## **LETTER FROM DON ROSS (Appendix E with Traffic Report)**

### **ADVICE FROM BEGA VALLEY SHIRE COUNCIL RE "ACCESS ROAD" FROM IVOR JONES DRIVE**

This is to outline my discussion with BVSC engineer, Peter Newton re the road.

Proposal Plan

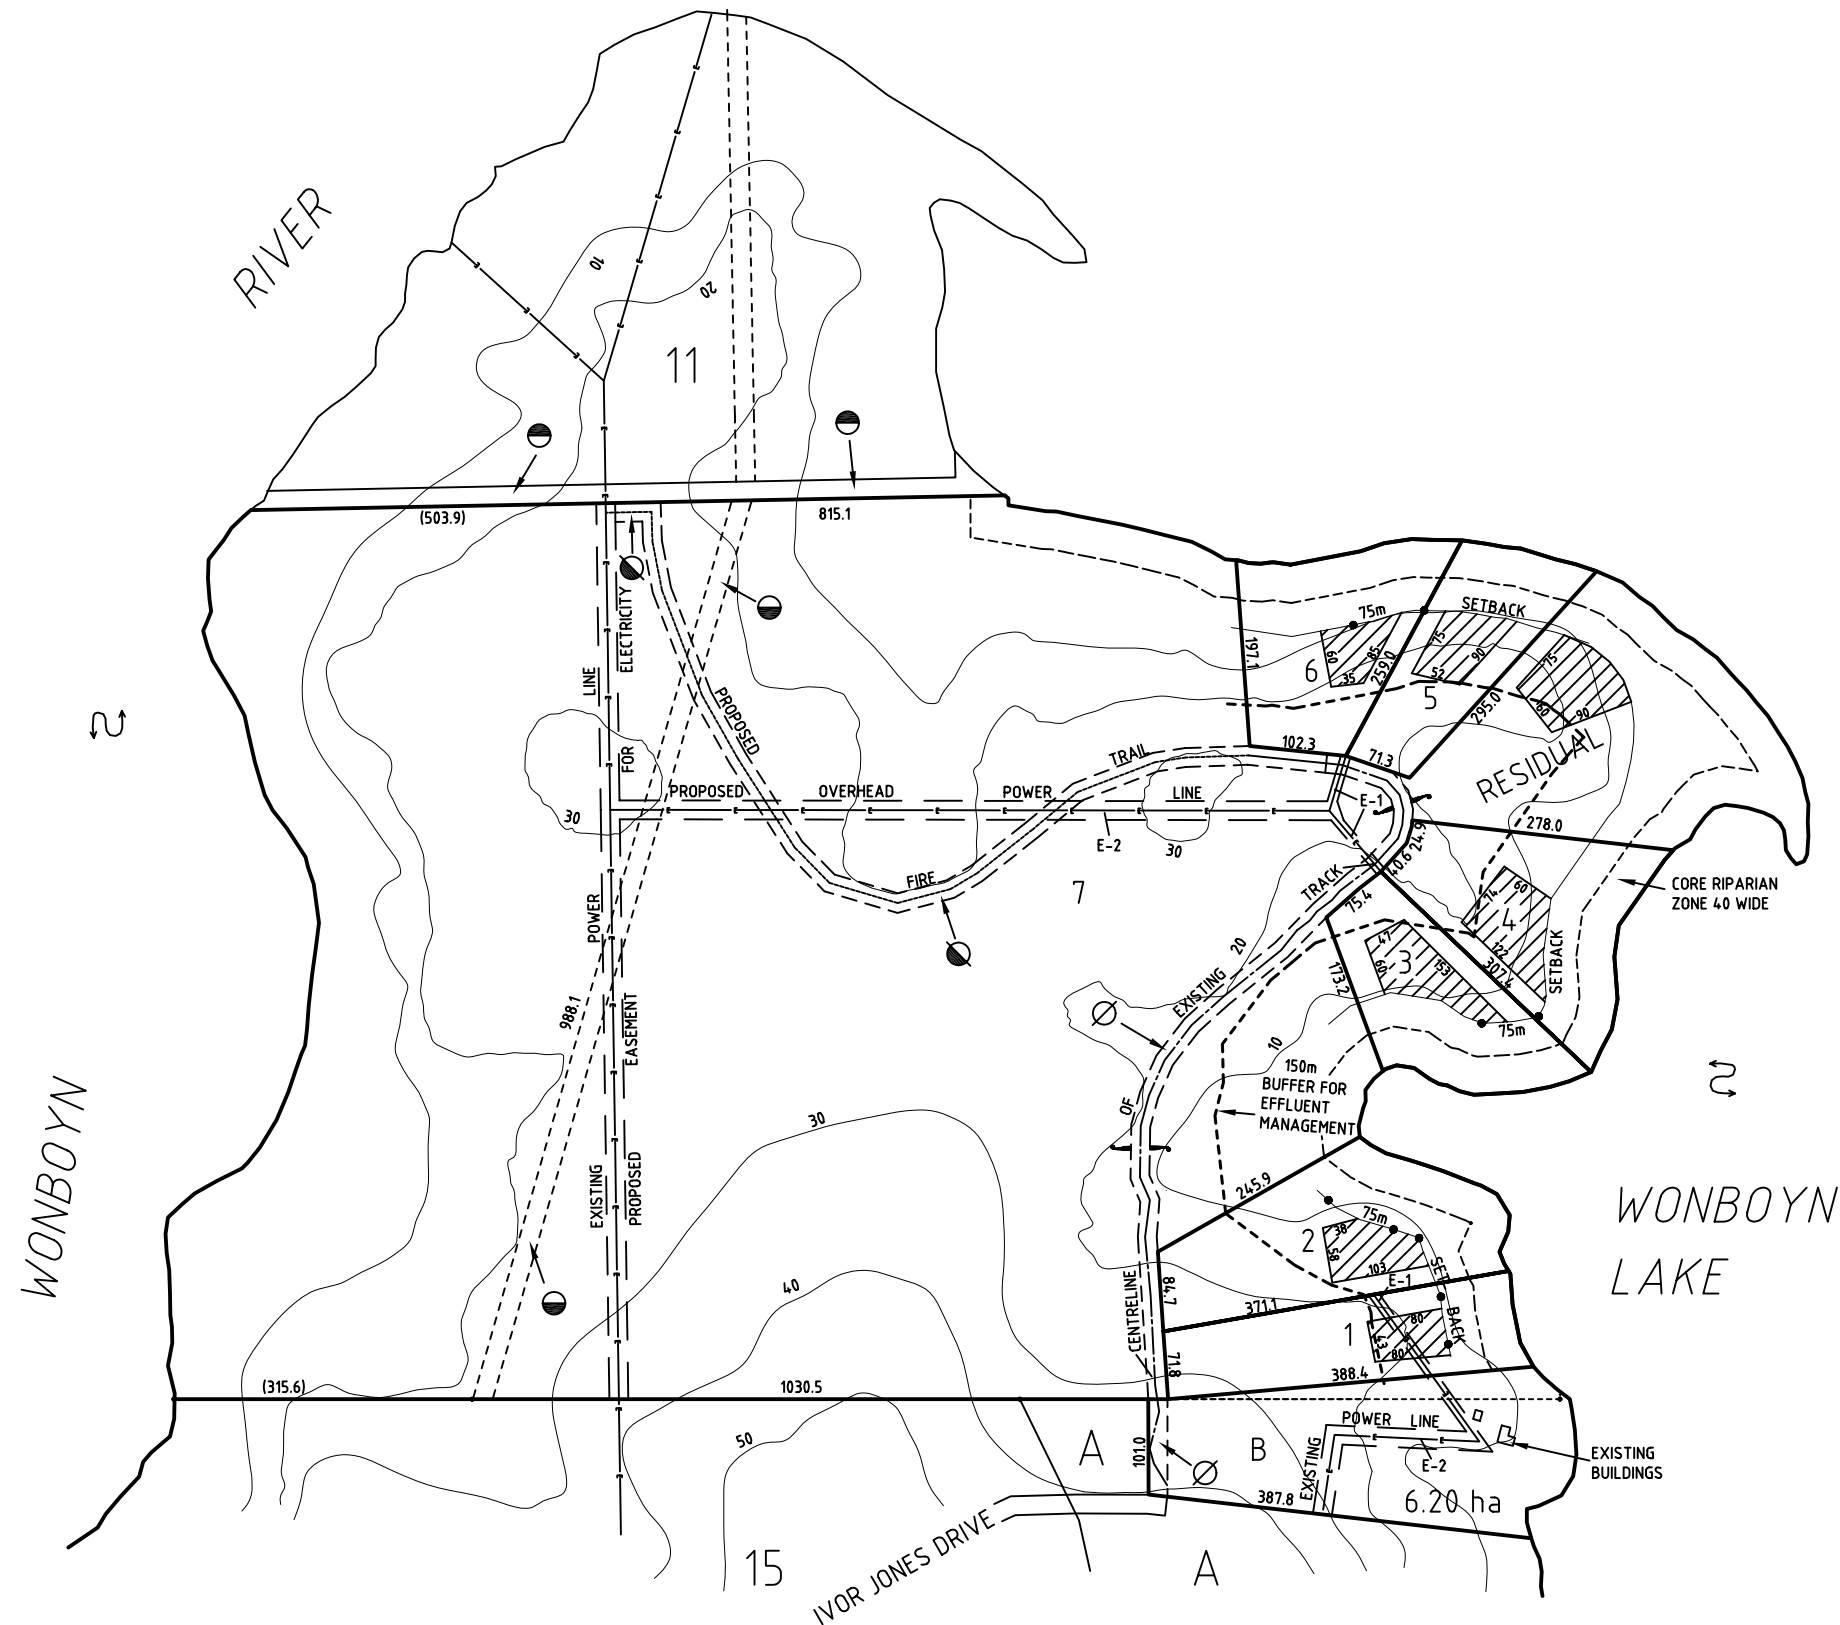
2. Peter said the road reserve must be 20 metres to allow for upgrading in the future if so required.
  3. Peter said that the road reserve must be within the residual land of Lot 14.

4. Peter agreed with the existing 4 metre road design to service the 7 Lots in Lot 14 provided the application to develop Lot 11 is withdrawn from council.

5. Peter indicated that the DoP would be guided by council's decisions on the road.
  6. Peter indicated that BVSC are not the controlling authority and that Rural Fire Service has the final say. He indicated that the existing road should be okay provided there was "leaf to leaf" clearing of 10 metres, i.e 3 metres each side of the 4 metre road.

- 1) No public road north of Ivor Jones Drive (Private Right of Way – ROW)
- 2) 20m road corridor (widen previously shown 15m for fire trail),
- 3) Retain road reserve within residual land of Lot 14,
- 4) 4m asphalt sealed road to serve 7 lots within Lot 14.
  - 4m unsealed (gravel) road within fire trail
  - application to subdivide Lot 11 will be withdrawn.
- 5) noted
- 6) incorporate "leaf to leaf" clearing of 10 metres, i.e 3 metres each side of the 4 metre road.
